Your ref: 23.0378  
Our ref: D3.23.0378  
Date: 13<sup>th</sup> June 2023

**App no: 23.0378**

**Address: Pendle Mill Pendle Road Clitheroe BB7 1JQ**

**Proposal: Reserved matters application relating to appearance/landscaping/layout/scale following outline planning permission 3/2022/0632**

Drawing Title: Proposed Site Plan with Topographical Survey

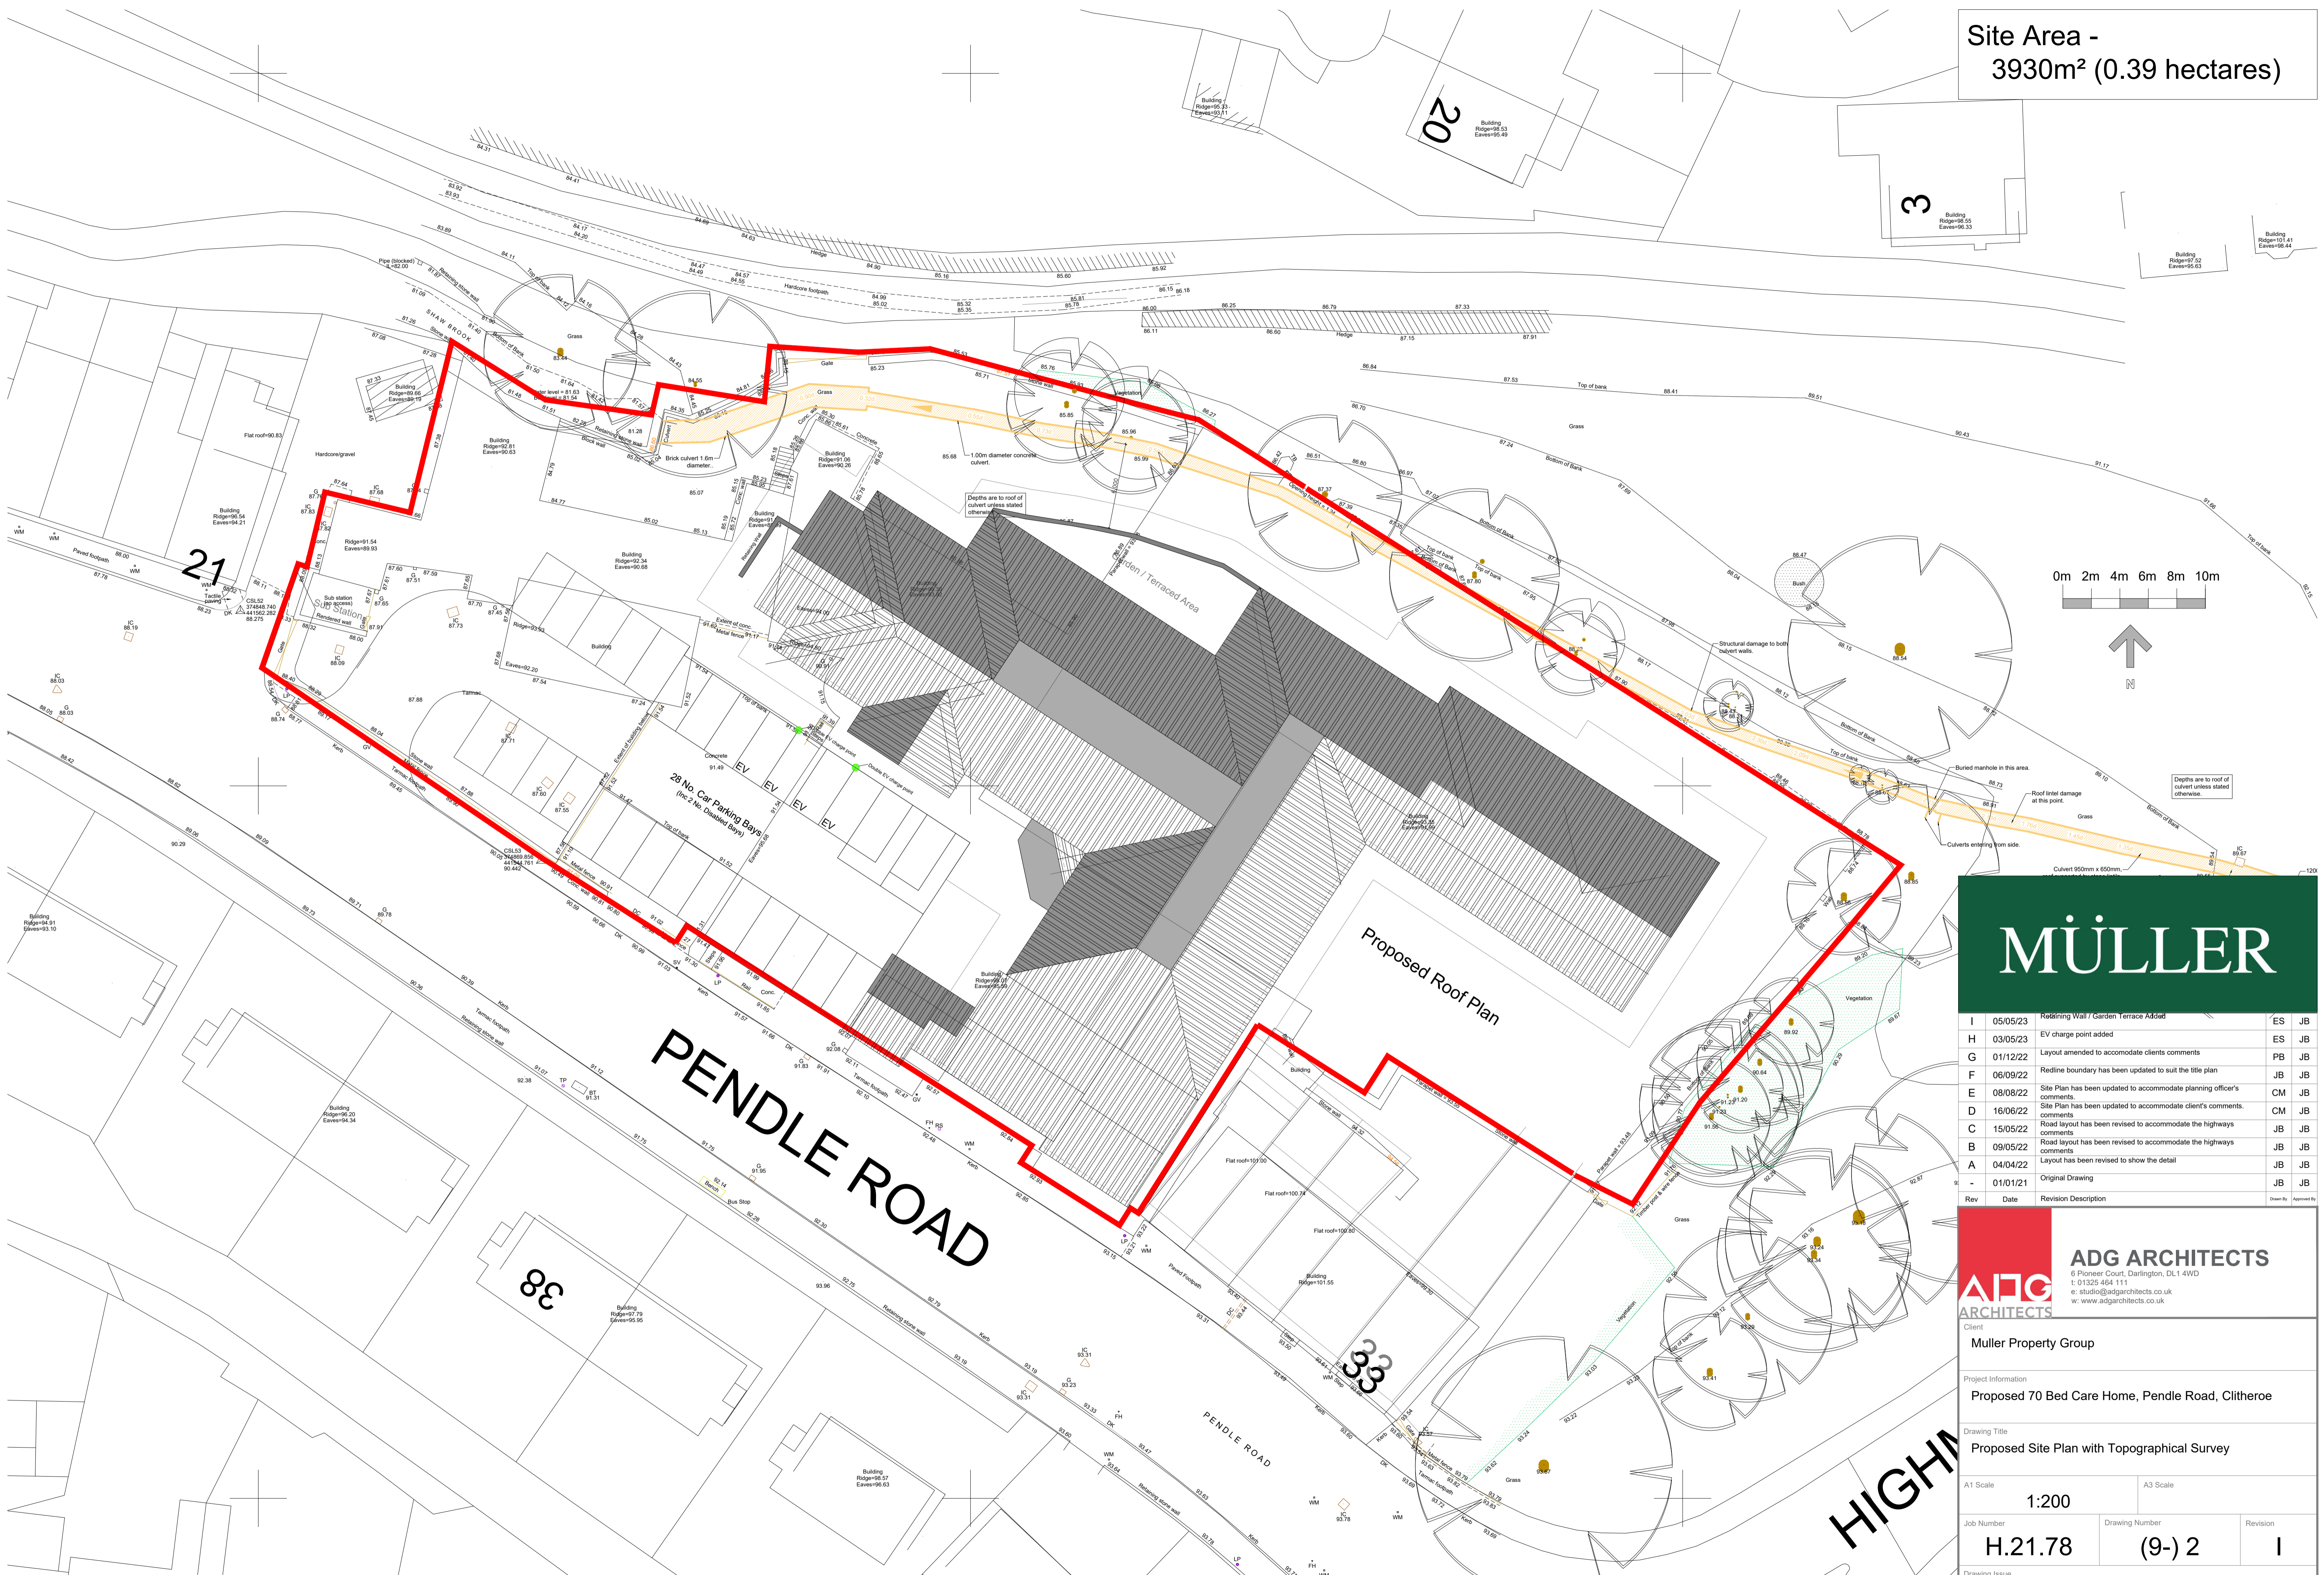
The parking provision is considered acceptable. In addition, a secure, covered bicycle store for a minimum of 3 bicycles will be required for staff and visitors to support sustainable travel.

At outline stage a swept path analysis was submitted for a refuse vehicle, ambulance and box van and it was evident that an internal turning area was required to allow vehicles to enter, turn and exit onto Pendle Road in forward gear. This was shown on drawing 'Sanderson drawing number 300828-001 Rev B' and this is considered necessary.

An amendment is requested to add the turning area to the design. We would request that the turning area has a hatched road marking to prevent parking.

To conclude an amendment is requested to add an internal turning area for service vehicles and a secure, covered cycle store for a minimum of 3 bicycles.

1. Prior to first use of the development hereby permitted, a secure, covered cycle store shall be erected and maintained thereafter for a minimum of 3 bicycles.
2. Prior to first use of the development hereby permitted, the car parking and internal turning area shall be constructed and marked out in accordance with the approved drawing.
